Application by WTI/EFW Holdings Ltd for Wheelabrator Kemsley K3 and WKN

The Examining Authority's further written questions and requests for information (ExQ2)

Issued on 6 May 2020

Graph 5.2.1: Maximum Predicted Process Contribution as Percentage of EAL vs Stack Height at Long-term IED Limits

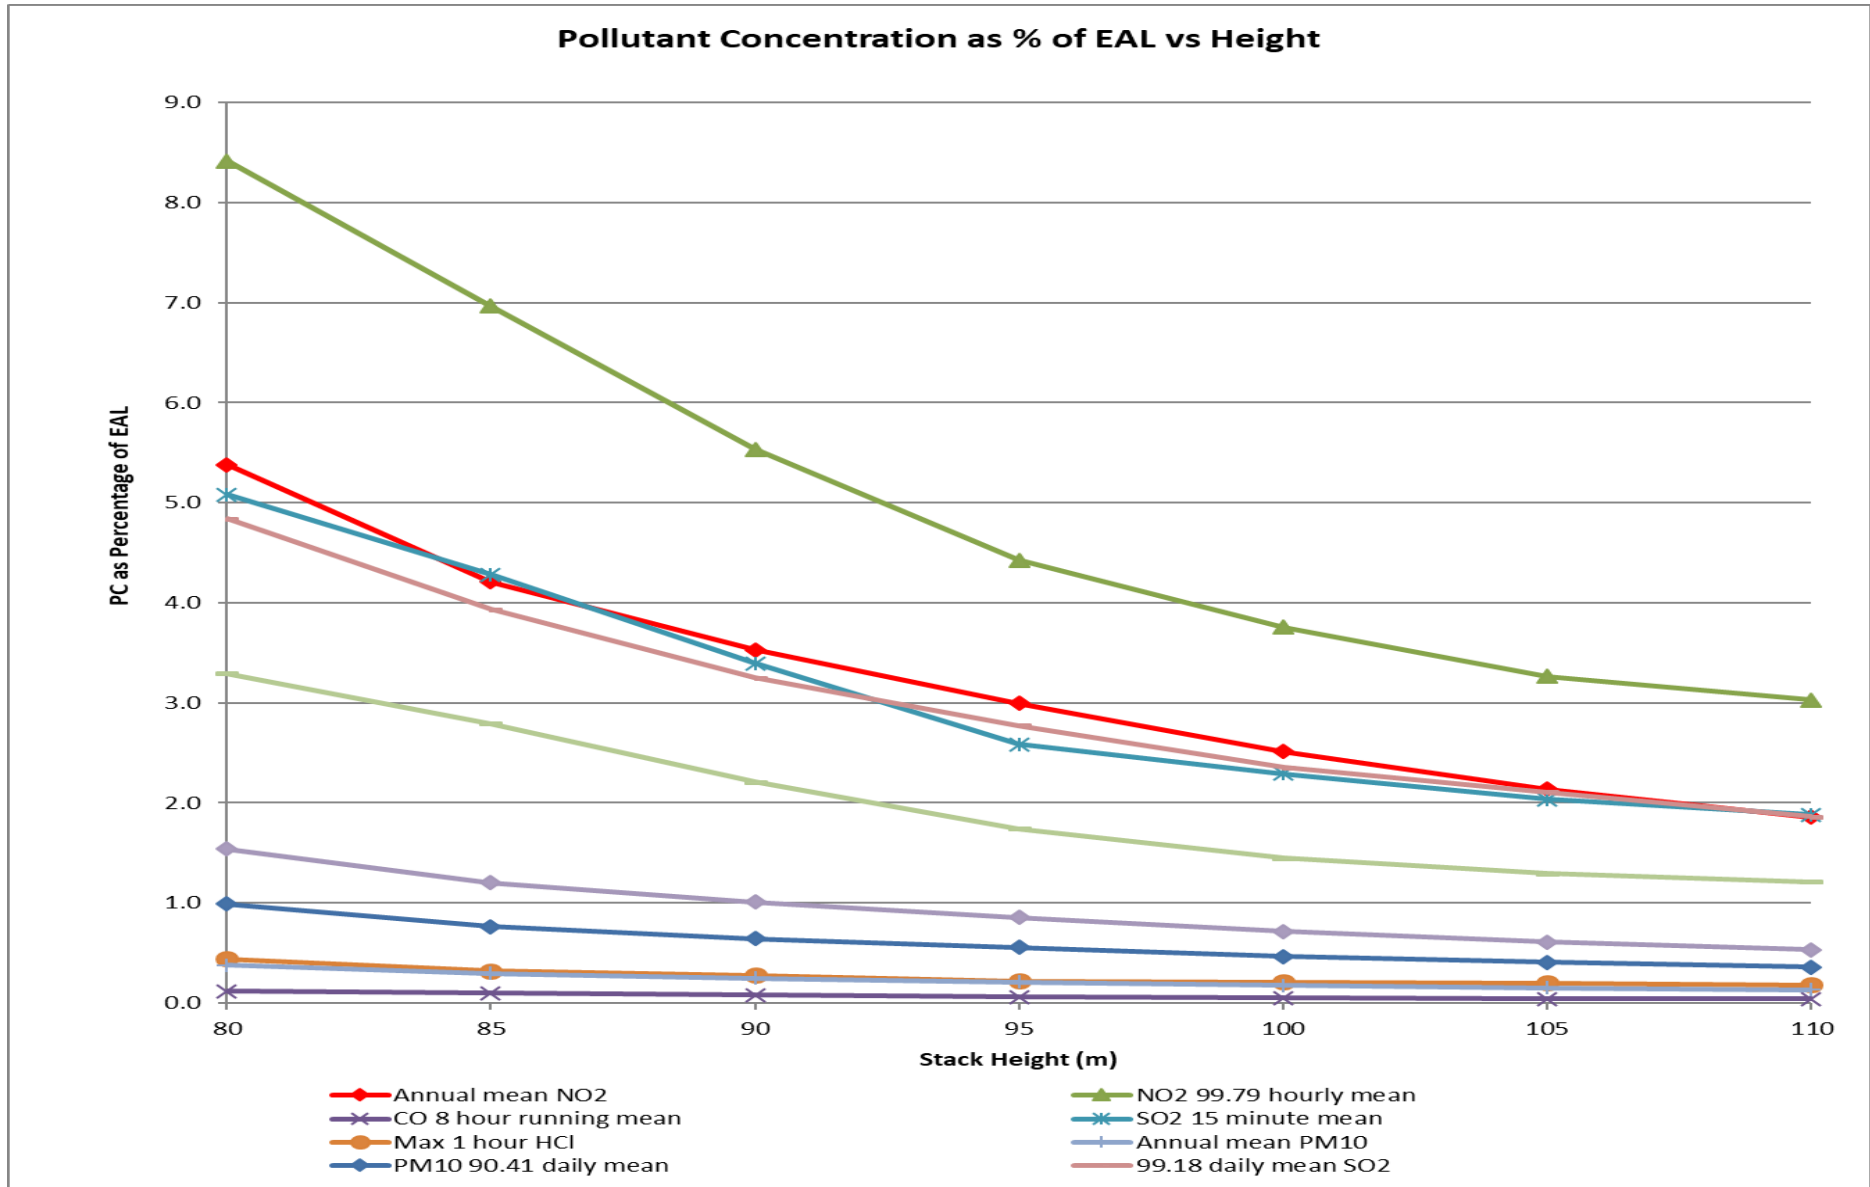
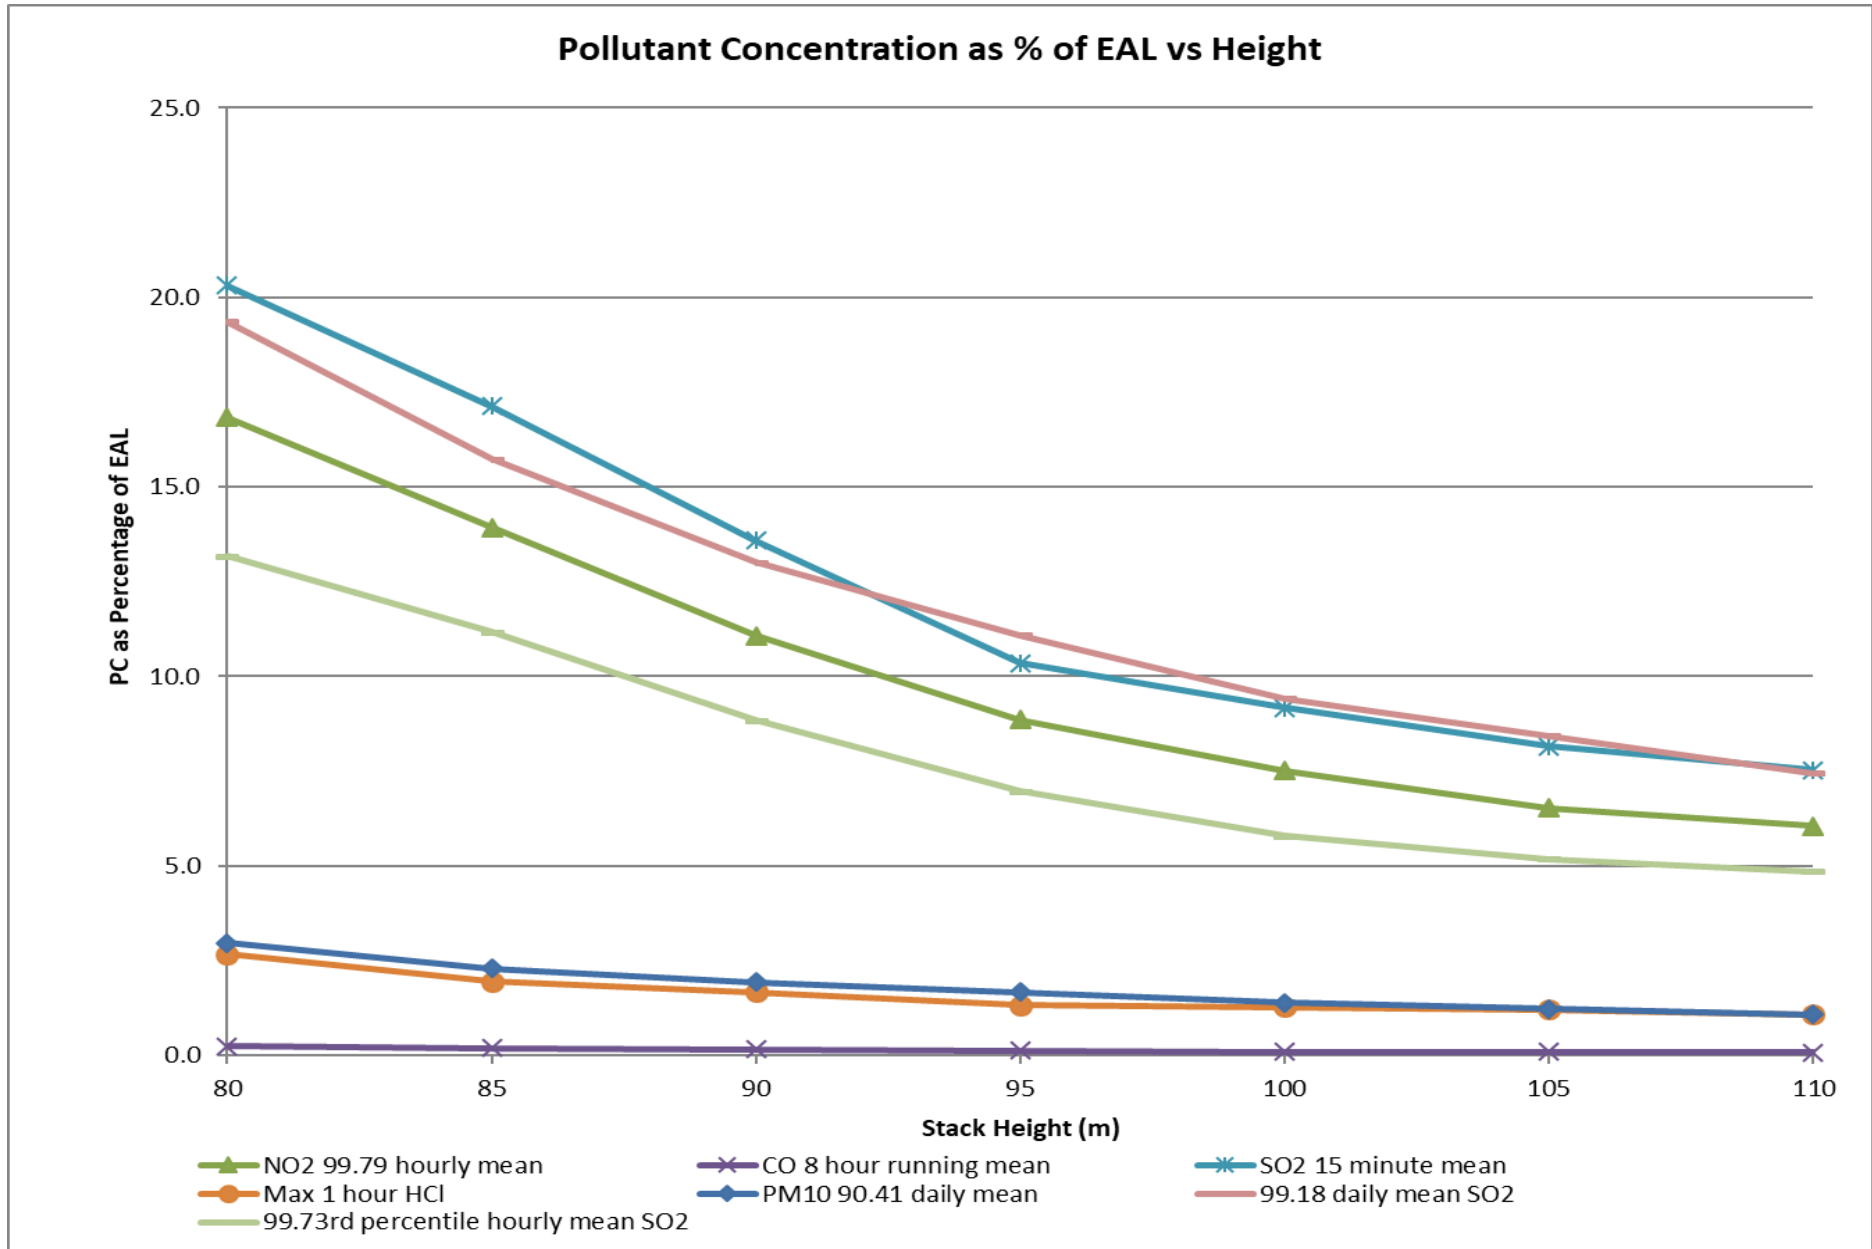
ExQ2	Question to:	Question:
Q2.5.12.	Applicant	<p>ES Appendix 5.2: Stack Height Determination for WKN is updated (no date in document) at D2 Submission [REP2-030, REP2-031]. It is stated that the stack height may be subject to change and may increase as the detailed design for the WKN Proposed Development continues to evolve. The stack height will be confirmed as part of the formal submission to PINS in spring 2020.</p> <p>The original submitted Stack Height Determination [APP-026] stated that the stack height would be confirmed as part of the formal submission to PINS in spring 2019. Please explain what submission or submissions have been made that confirms the stack height within the Proposed Development.</p>
Q2.6.	Greenhouse Gases and Climate Change	
Q2.6.1.		None at this time
Q2.7.	Ground Conditions	
Q2.7.1.		None at this time
Q2.8.	Habitats Regulations Assessment (HRA)	
Q2.8.1.	Applicant	<p>Regarding ExQ1.8.10 and HRAR paras 3.1 and 3.11, an in-combination effects (ICE) assessment of the project together with other plans and projects should take place at both screening and AA stage. No screening ICE assessment appears to have been undertaken, as it is not presented in the screening matrices, only the integrity matrices. Please provide a separate assessment of the ICE for the screening stage and reflect this in updated matrices.</p>
